**CHARLOTTE - MECKLENBURG**  
**PLANNING COMMISSION**

**INTER - OFFICE COMMUNICATION**

**SUBJECT:** Administrative Approval for Petition No. 2007-017 by The McAlpine Group, LLC.

VOLUNTEER FIRESTATION ELEVATIONS

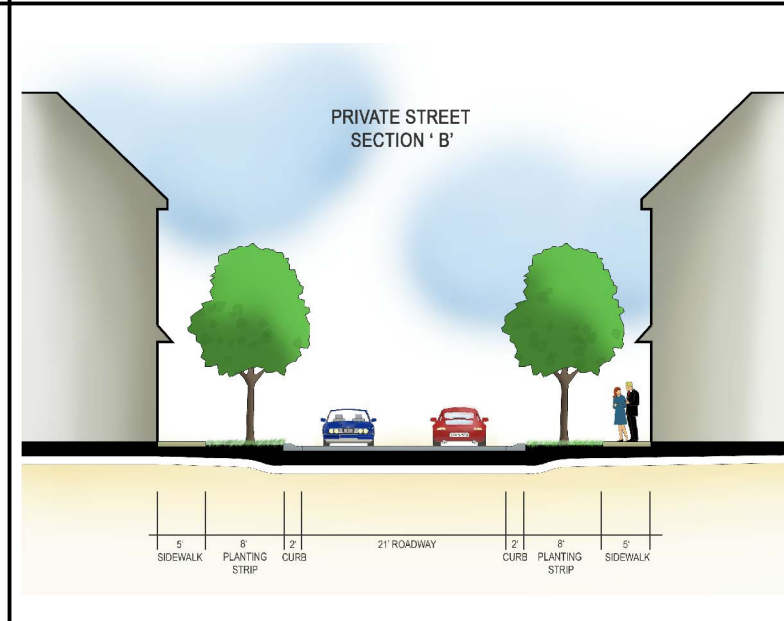
Attached are revised plans for the above rezoning petition. The plans have been revised to show an increase in the allowable square footage for the Fire Station from 5,170 to 5,660 with minor changes to the building elevations. Since these changes do not alter the intent of the development and are minor, I am administratively approving these revised plans. Please use these revised plans when evaluating requests for building permits and certificates of occupancy.
